Vincentia Coastal Village - Town Centre (MP06_0025-Mod-8)
Request for Additional Information

I refer to the above application to modify the approval for the Vincentia Coastal Village - Town Centre (MP06_0025-Mod-8). After careful consideration, the Department is requesting that you provide additional information.

drawing title
OPTION 01_VINCENTIA
DISTRICT TOWN CENTRE MOD
8 DESIGN RESPONSE

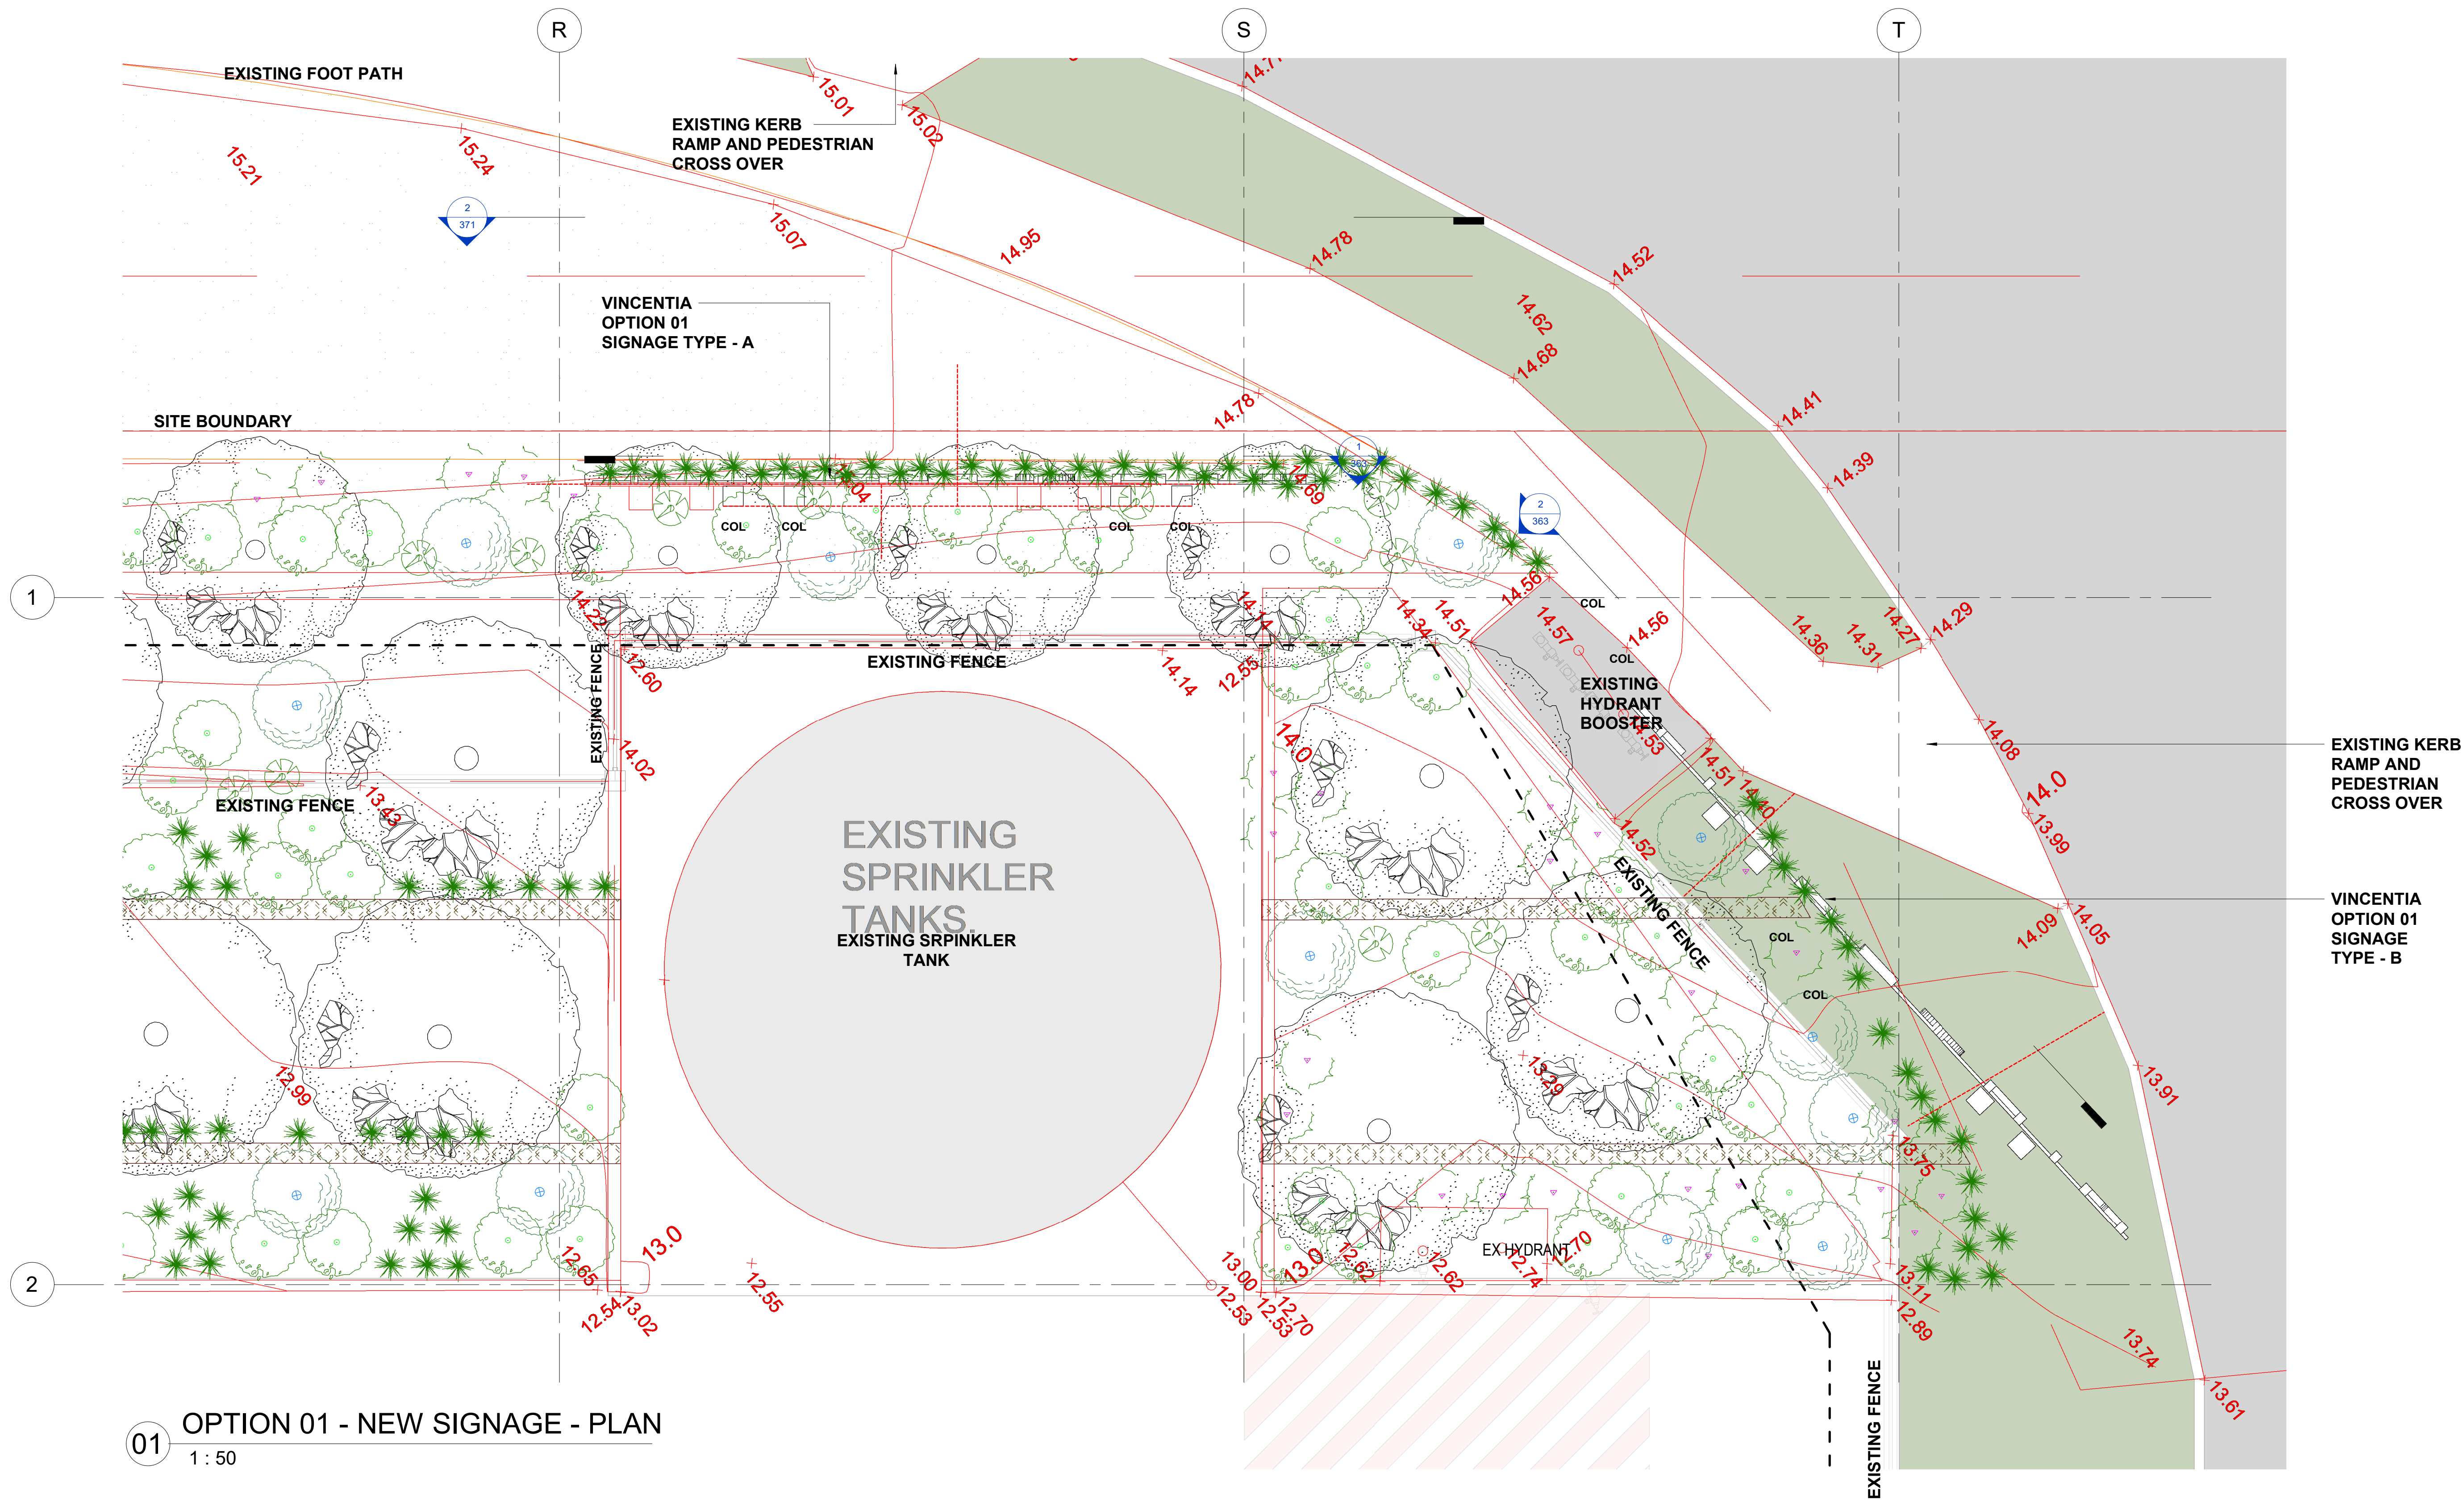
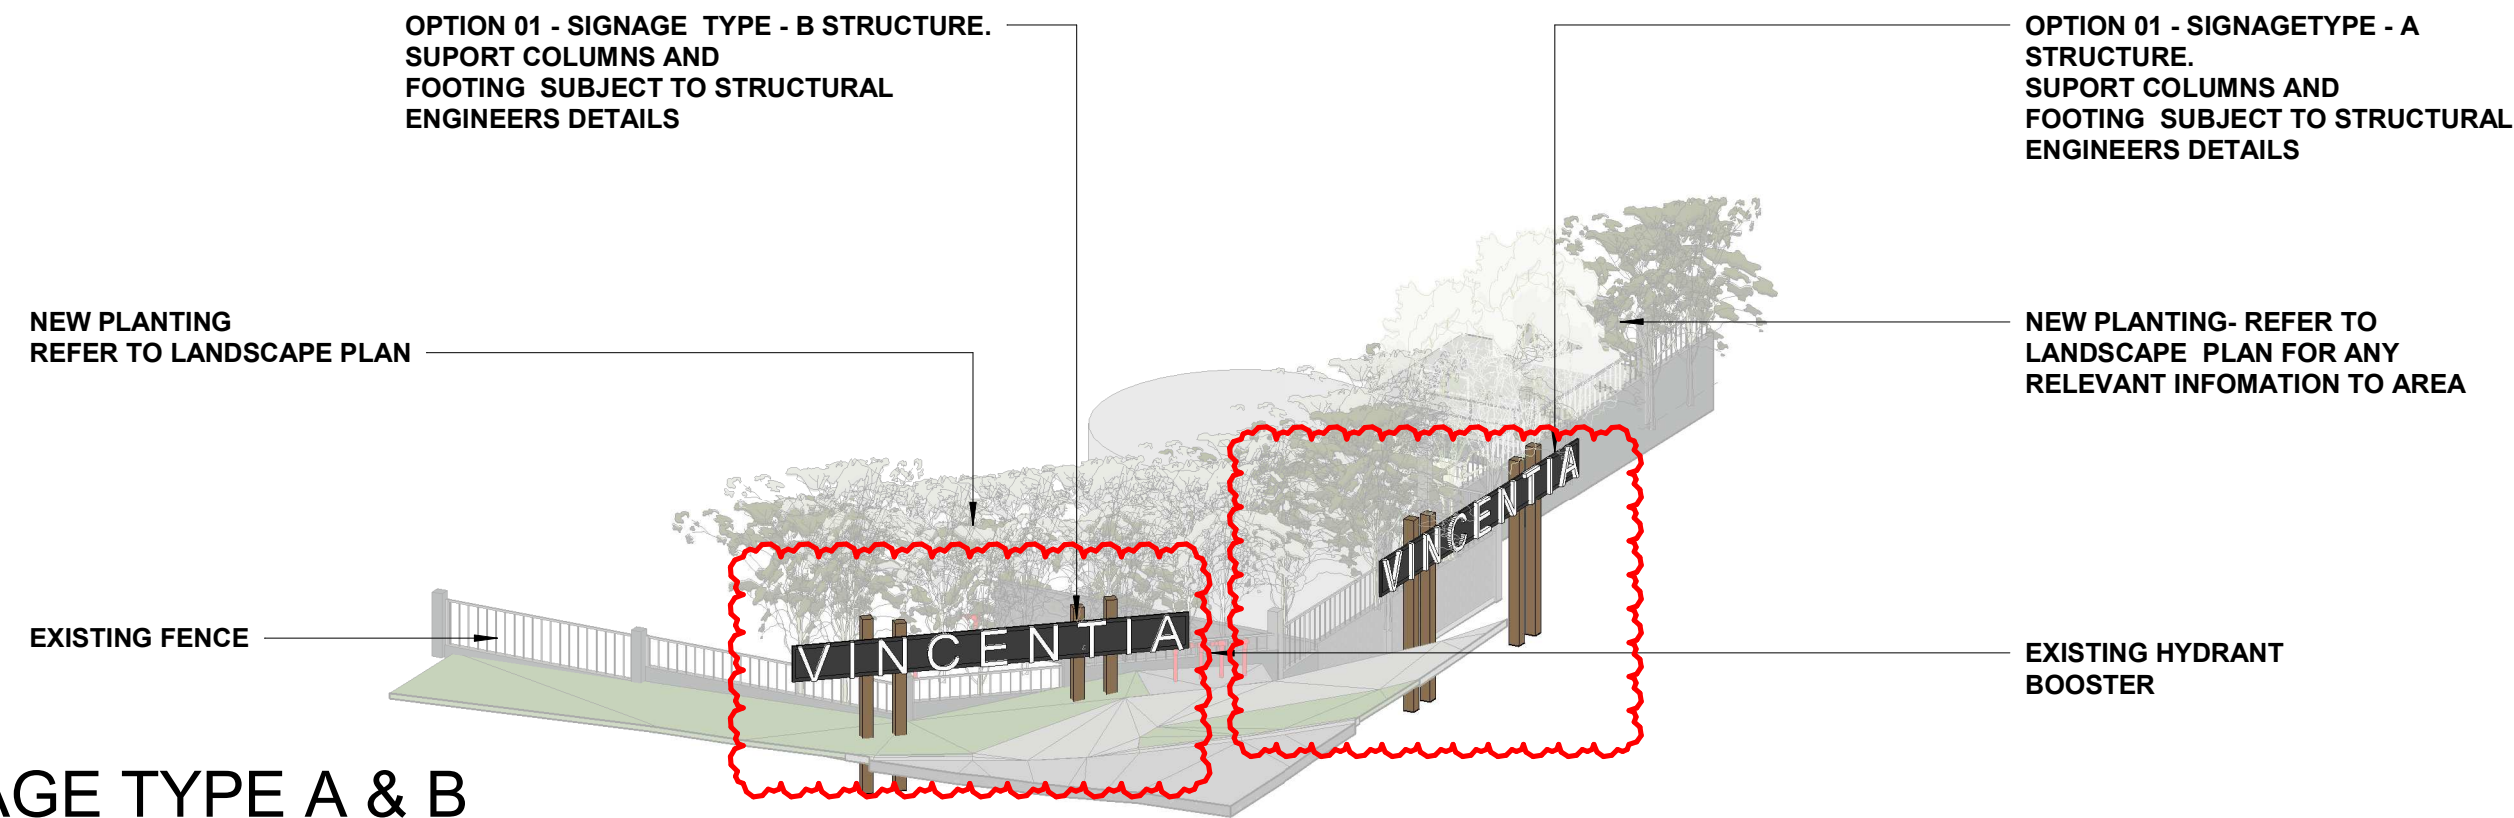
The Department requests more detail around the proposal's impact on access to the existing fire hydrant booster on the corner of Moona Creek Road and the Halloran Street roundabout. Please provide advice from an accredited specialist to confirm the proposal maintains unimpeded access to the booster.
